SEARs for MLC Burwood Senior School Centre (SSD 6484) 45 Park Road, Burwood

Secretary's Environmental Assessment Requirements

Application Number	SSD 6484
Proposal Name	MLC Burwood Senior School Centre
Location	45 Park Street, Burwood
Applicant	MLC School
Date of Issue	14 May 2014
General Requirements	The Environmental Impact Statement (EIS) must meet the minimum form and content requirements in clauses 6 and 7 of Schedule 2 the <i>Environmental Planning and Assessment Regulation 2000</i>. Notwithstanding the key issues specified below, the EIS must include an environmental risk assessment to identify the potential environmental impacts associated with the development. Where relevant, the assessment of the key issues below, and any other significant issues identified in the risk assessment, must include: • adequate baseline data; • consideration of potential cumulative impacts due to other development in the vicinity; and • measures to avoid, minimise and if necessary, offset the predicted impacts, including detailed contingency plans for managing any significant risks to the environment. The EIS must be accompanied by a report from a qualified quantity surveyor providing: • a det

SHADOW DIAGRAMS
SHEET 01

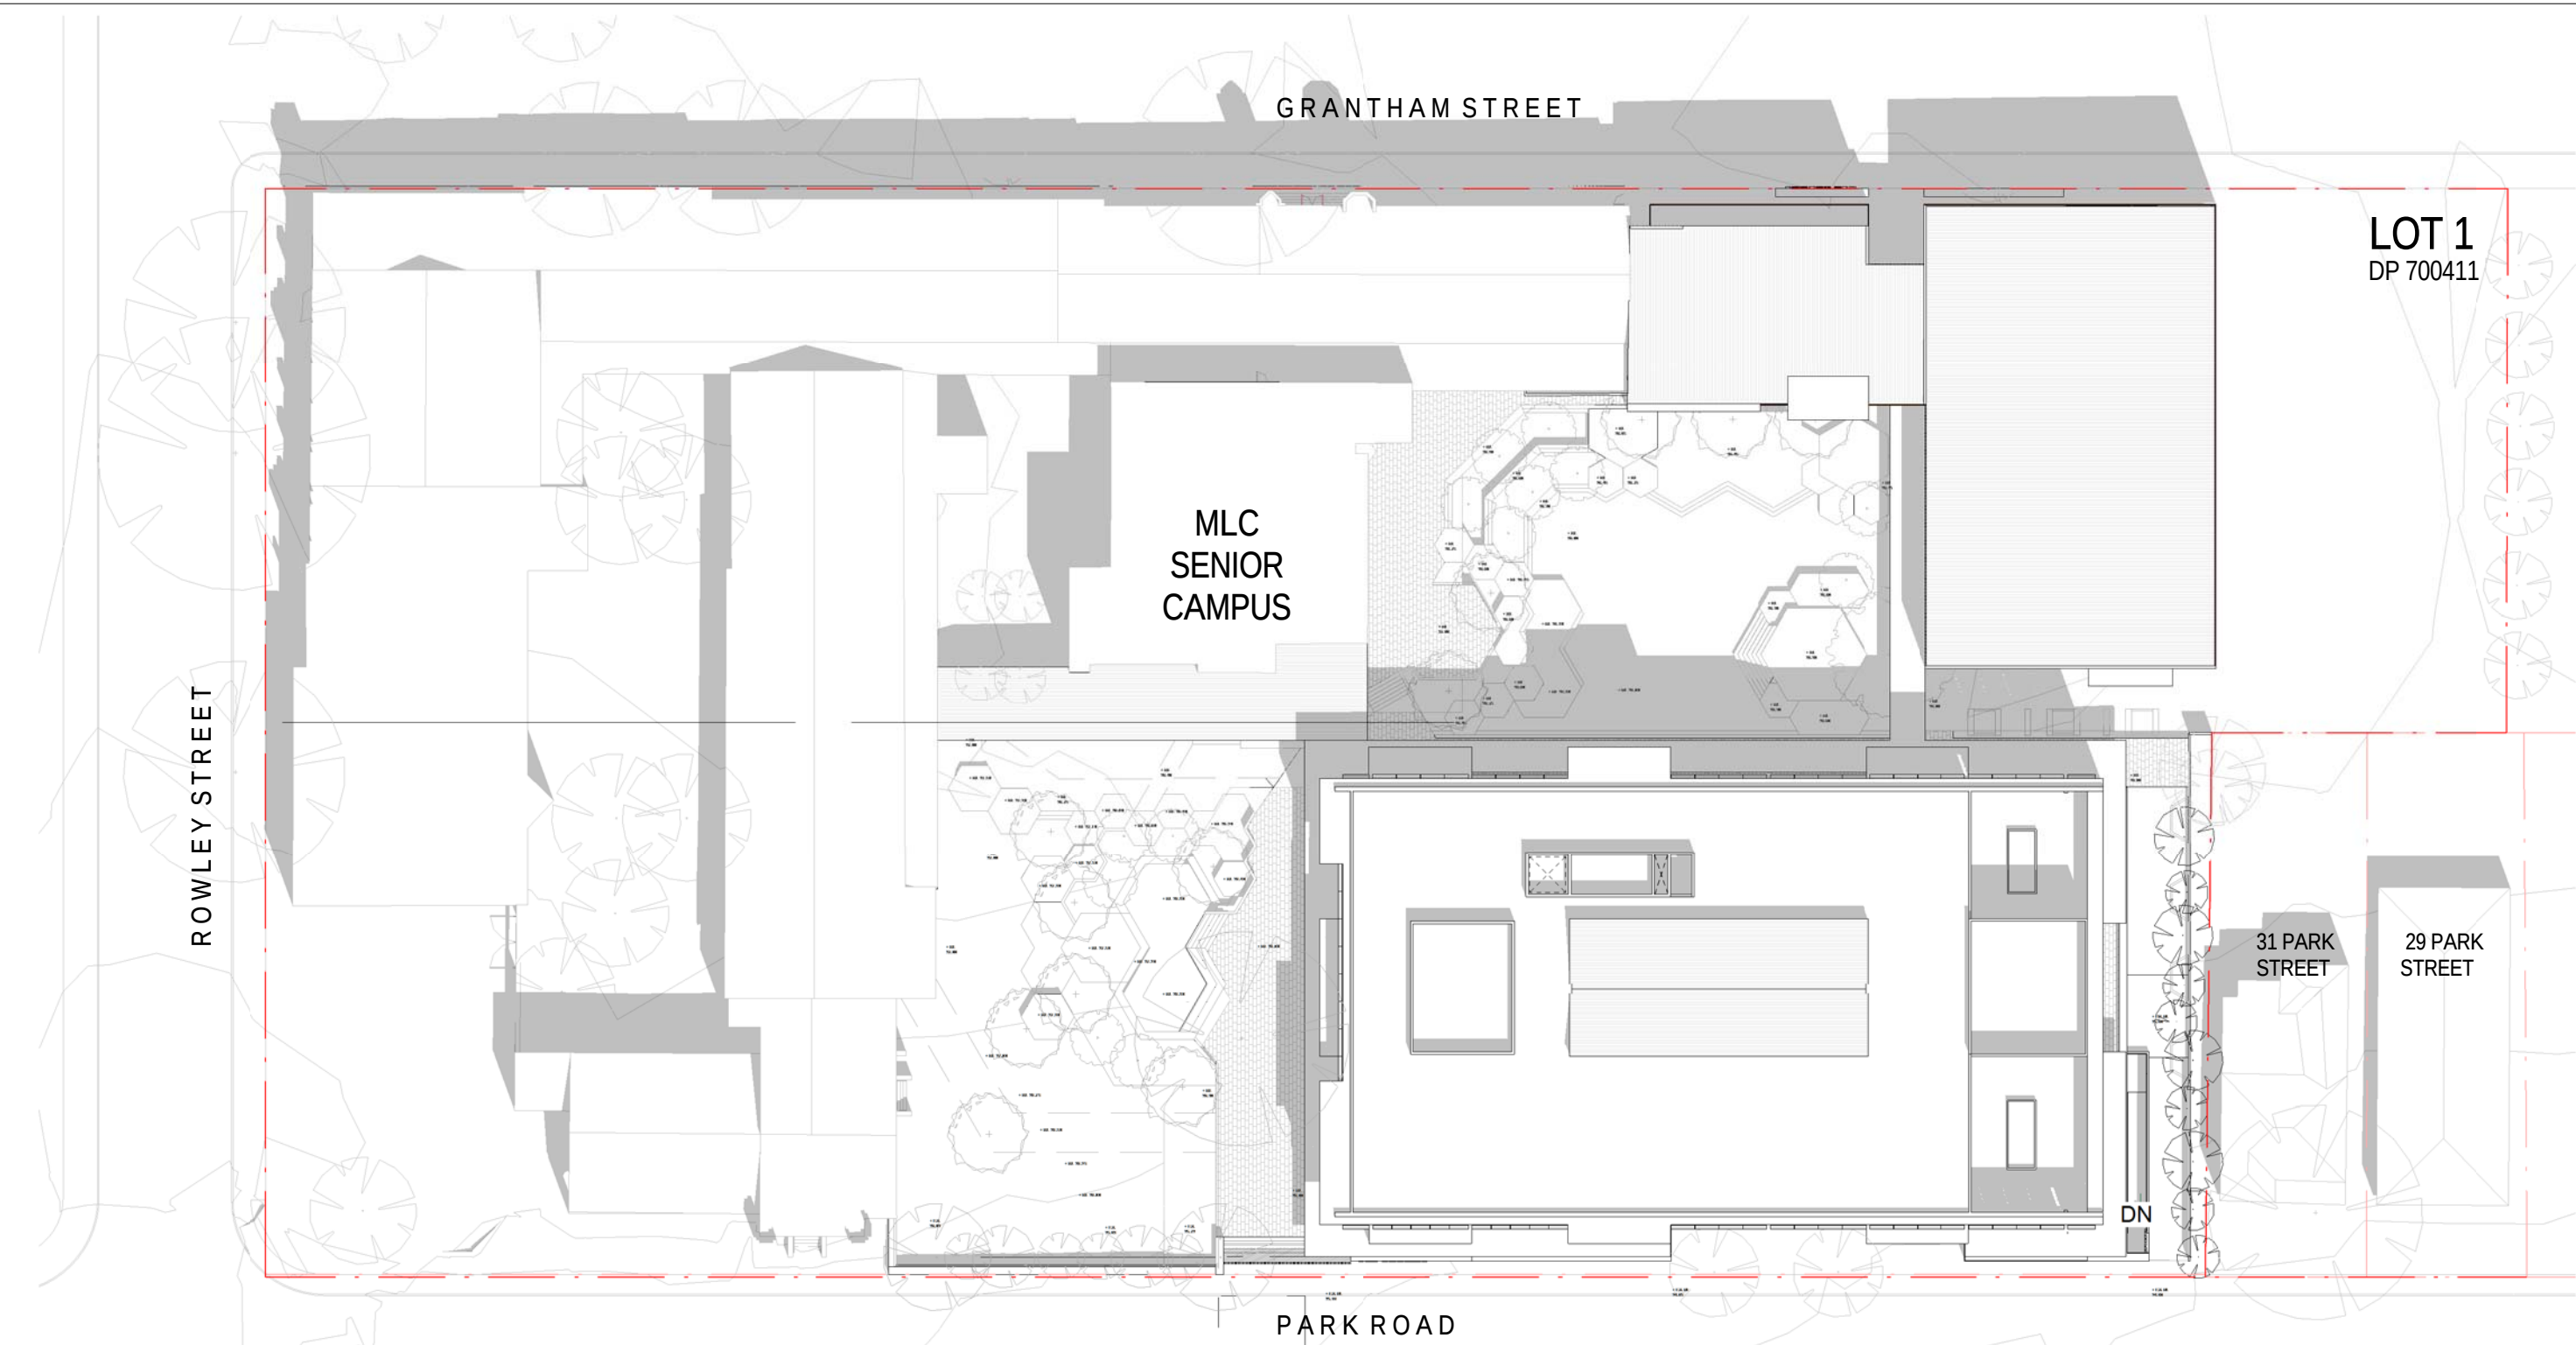
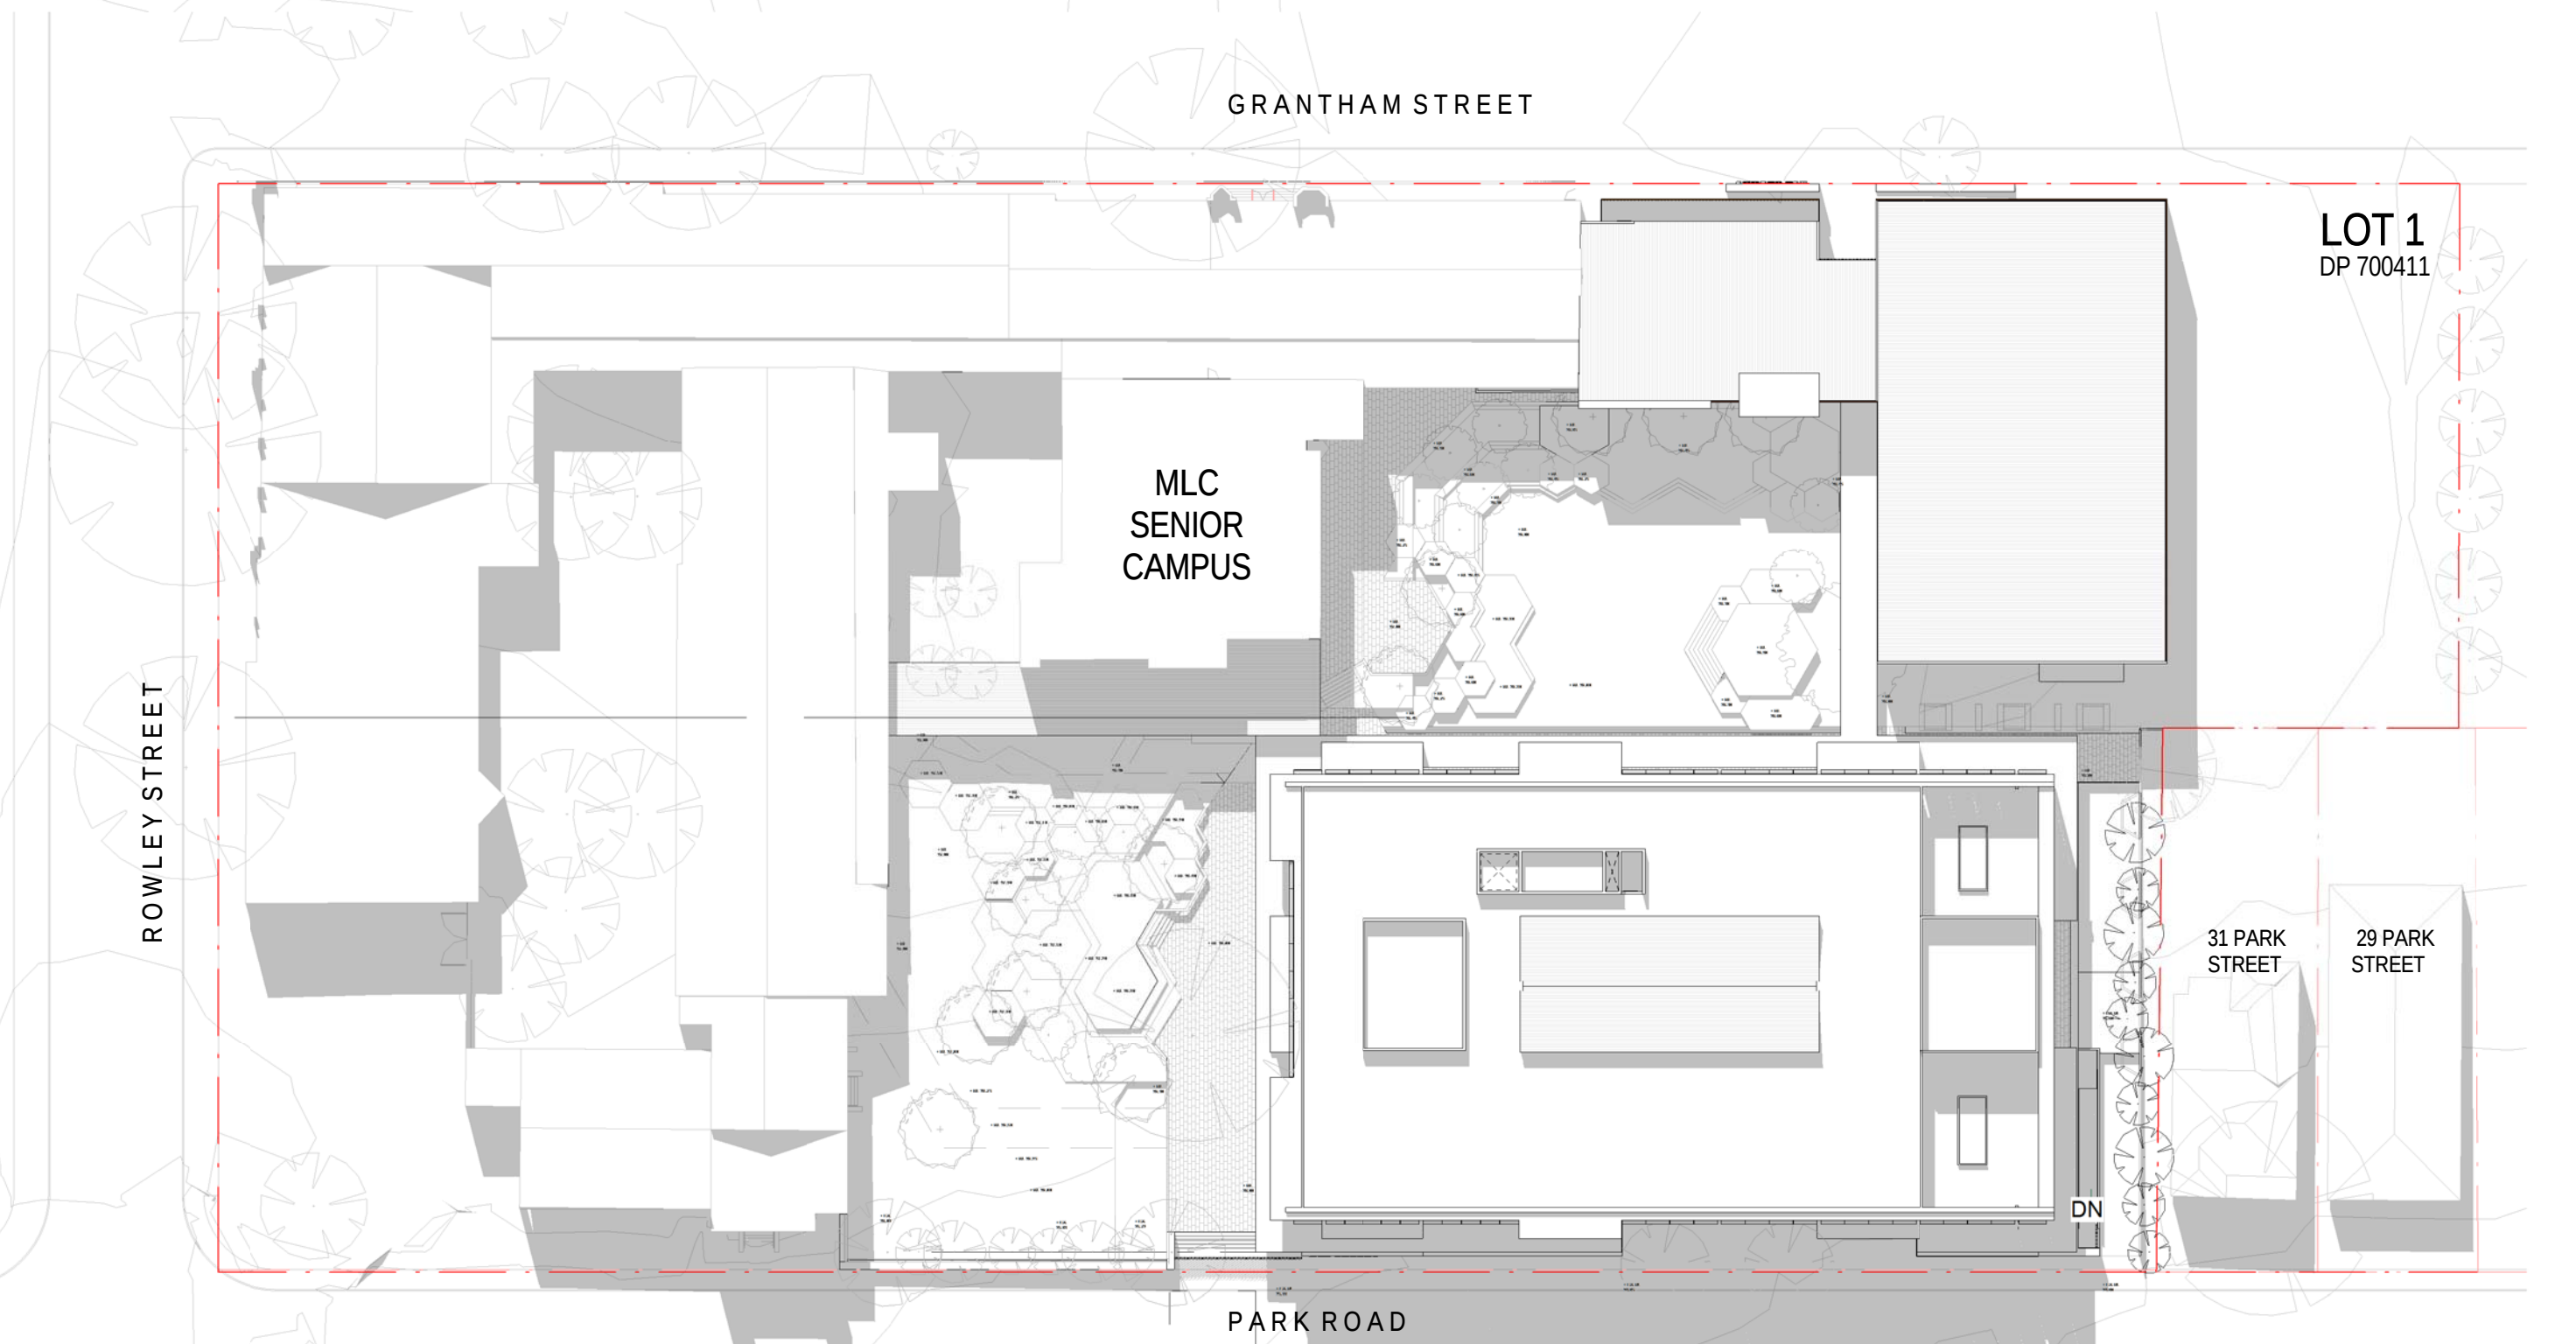
- Particular concerns are raised about potential impacts of overlooking and reduced privacy on the dwelling houses located immediately to the north of the proposed new teaching and learning building, in particular to the balconies where student noise and overlooking are potential issues. Noise abatement and privacy screening of residential properties to the north are considered necessary. The finish to the solar/ privacy screens and reflectivity matters need to be given consideration. Justification will need to be provided that this building cannot be lowered to reduce its impact in the north east corner.
